RESPONSE TO SUBMISSIONS – BUILDING R4A SSD 6964 MOD 4

This response to submissions letter has been prepared following the public exhibition of a Section 4.55(1A) modification application for Residential Building R4A, Barangaroo (SSD 6964 MOD 4). This modification seeks approval for internal and external design changes and administrative amendments to conditions. The modification application is supported by concurrent modification applications to the adjacent Residential Building R4B (SSD 6965 and SSD 8892218).

GF Landscape Plan approved under S4.55 Mod 2

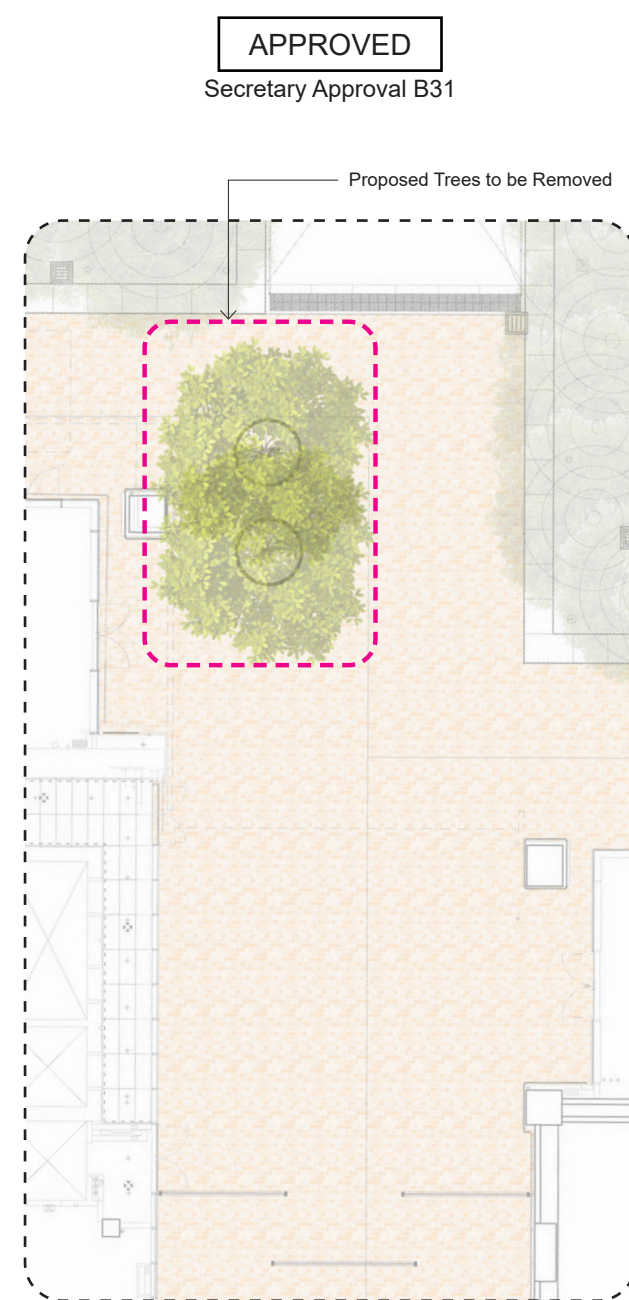
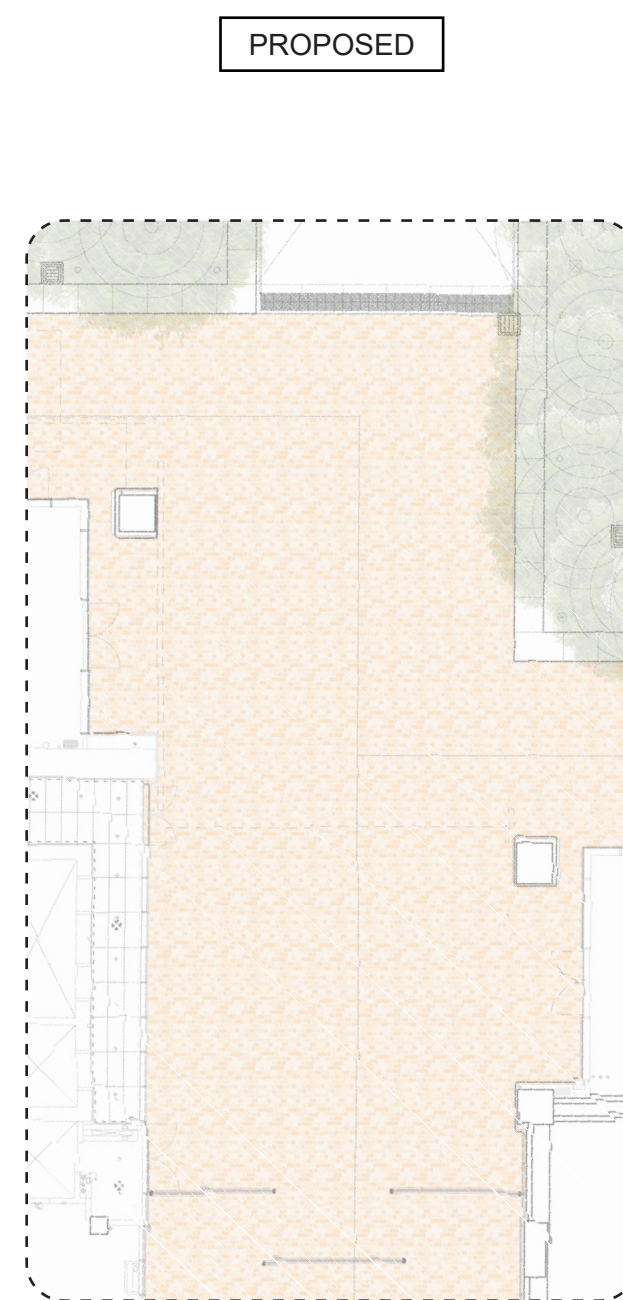
Council raised the following query relating to the removal of two trees at Hickson Park entrance to R4A.

The City questions the need for the removal of the two trees when considering the long-term impacts of the trees on sightlines to Hickson Park. Although it is acknowledged that there is significant planting approved in Hickson Park, any removal of future canopy coverage should be avoided as the benefits of additional canopy to pedestrian amenity outweigh potential impacts, particularly in relation to wind protection and shading in addition to general heat mitigation. As the trees mature, it is unlikely that pedestrian sightlines would be significantly impacted, and reconsideration should be given to maintaining the trees as approved.

The two trees at an entrance to Building R4A were first approved in 2017, prior to the broader Barangaroo South Public Domain DA (SSD 7944) being finalised and approved. The final design of the Barangaroo South Public Domain provided for a extensive tree planting in a tree belt along Hickson Park (approximately 53 trees), the actual Hickson Park (12 trees), the adjoining streets and the public domain entry points to Hickson Park. The Public Domain design approved and now largely implemented under SSD 7944 results in a significant number of trees across Barangaroo South. The extent of the tree planting approved under SSD 7944 is shown in **Figure 1**.

The tree belt approved under SSD 7944 frames the substantial areas of paved public open space around the base of the residential buildings, providing a division to Hickson Park. As part of design development, it has become clear that the two trees approved under the Building R4A development consent are not consistent with this strategy of tree planting, and instead congest the sightlines to the entrances of Building R4A and general navigation and wayfinding through the site. The preference is to keep the public spaces near the building entrances clear and easy to navigate. Further to this, the two trees are also concerning for their potential to generally impede sightlines from the Strada between Building R4A and R4B through to Hickson Park. Therefore, as these trees are inconsistent with the Public Domain DA planting strategy and inhibit visibility around the bases of the towers, it is proposed to remove these trees.
